YorkshireWater

**Your Ref: 2025/1092
Our Ref: B/01496**

Non-motorised user (NMU) bridge over A633 Grange Lane (A633), Stairfoot, Barnsley - (BARNs) Demolition of existing non-motorised user (NMU) bridge, and construction of replacement NMU bridge

- 70111595-WSP-ELS-AZ-DR-LA-000021

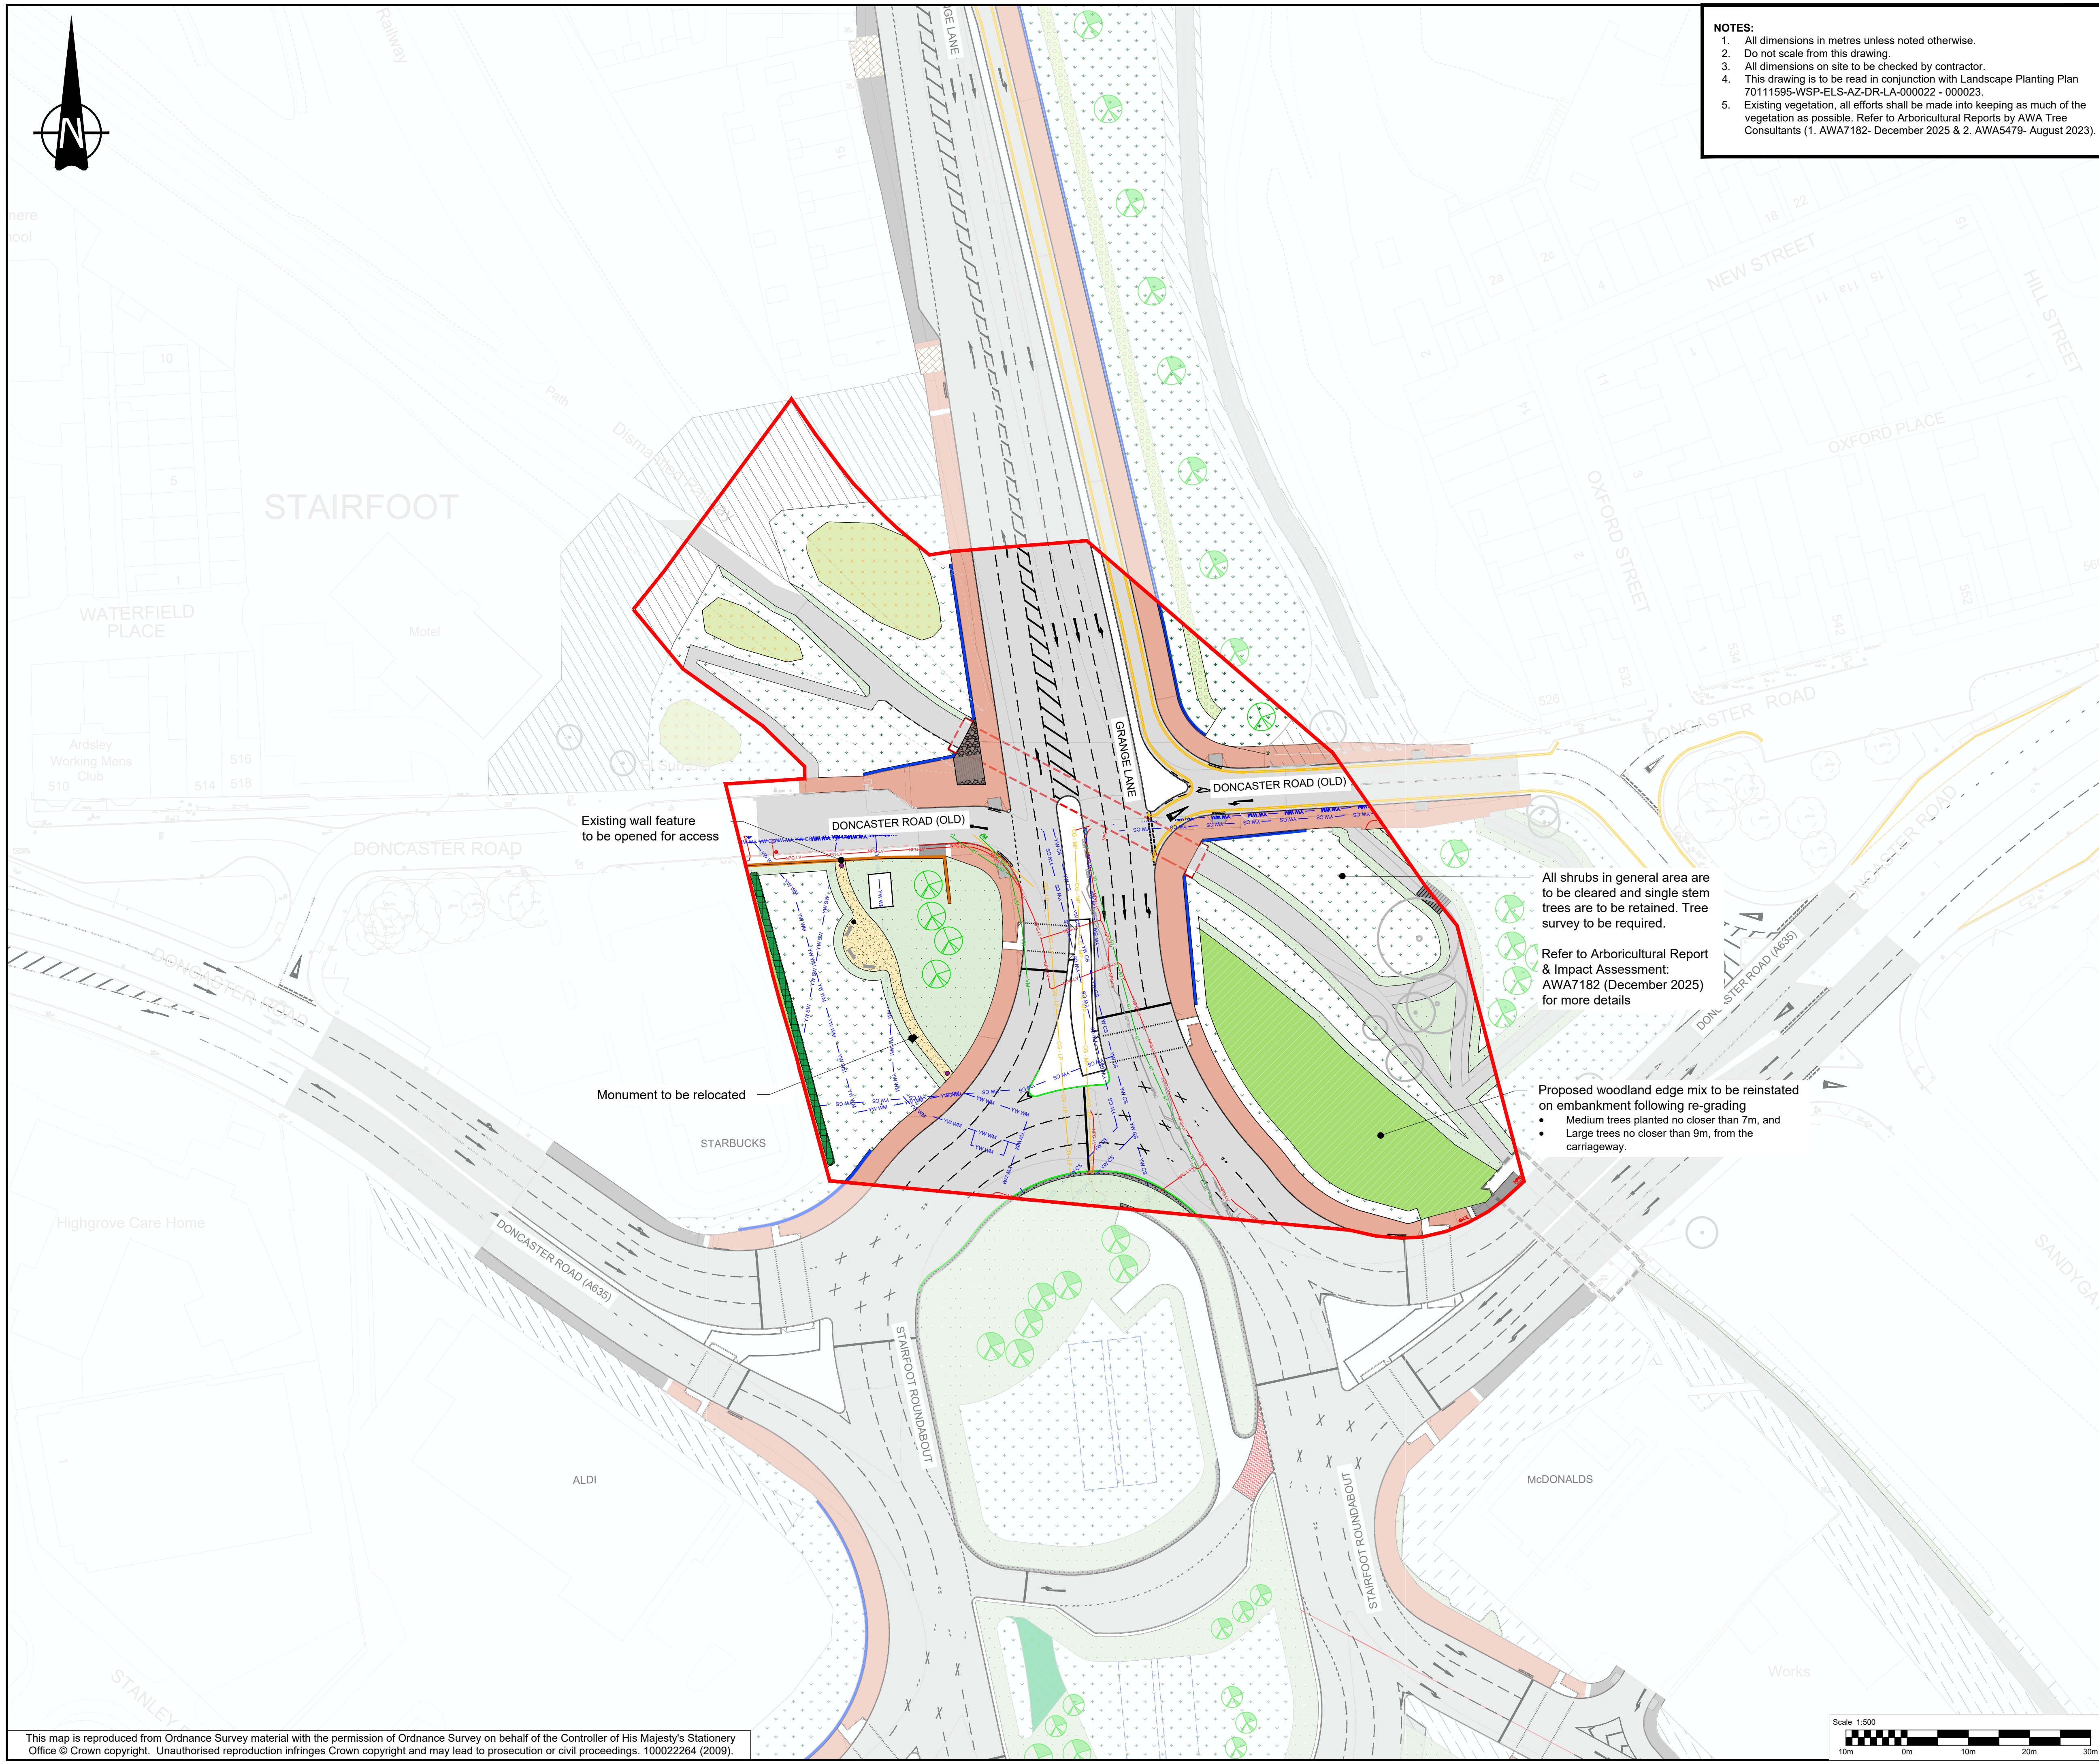
1.) The drainage details submitted on drawing 'Landscape General Arrangement' 70111595-WSP-ELS-AZ-DR-LA-000021(revision P01) dated 15/12/25 that has been prepared by WSP is not acceptable. The following point(s) should be addressed:

- a.) the submitted drawing appears to show a new tree planting within 6 metres of the public water network
- b.) the submitted drawing should show the site-surveyed position of the public water main crossing the site
- c.) the submitted drawing should show the required water main easement -- or an agreed alternative scheme

An existing water pumping station is housed in a light weight building protected by a security cage within the grounds of the former Black Bull PH, which is proposed to become a landscaped area of wildflower and amenity grass. The pumping station location is not marked on the landscape plans but will have to remain in-situ, near the proposed resin footway.

Additionally, two large diameter water mains associated with the pumping station cross the area which is due to be landscaped. Due to the risk of root spread causing problems with the maintenance of the mains, no trees should be planted within 6m of each water main or pump house, which includes the Hornbeam, Oak, Cherry, Alder and Lime which have been proposed. Smaller trees may be planted in such a way that the eventual root spread reaches no closer than one metre from the main.

1.) The drainage details submitted on drawing 'Landscape General Arrangement' 70111595-WSP-ELS-AZ-DR-LA-000021(revision P01) dated 15/12/25 that has been prepared by WSP is not acceptable. The following point(s) should be addressed:

- a.) the submitted drawing appears to show a new tree planting within 5 metres of the public sewer network
- b.) the submitted drawing should show the site-surveyed position of the public sewer crossing the site
- c.) the submitted drawing should show the required building stand-off from public sewer -- or an agreed alternative scheme

On the Statutory Sewer Map, there is a 675mm diameter surface water sewer, and a 300mm combined water sewer recorded to cross the site. It is essential that the presence of this infrastructure is taken into account in the design of the scheme.

In the instance of the 675mm sewer, a stand-off distance of 4 (four) metres is required at each side of the sewer centre-line and it may not be acceptable to raise or lower ground levels over the sewer, nor to restrict access to the manholes on the sewer.

In the instance of the 300mm sewer, a stand-off distance of 3 (three) metres is required at each side of the sewer centre-line and it may not be acceptable to raise or lower ground levels over the sewer, nor to restrict access to the manholes on the sewer.

There should be no new tree planting within 5 metres of the public sewer network.
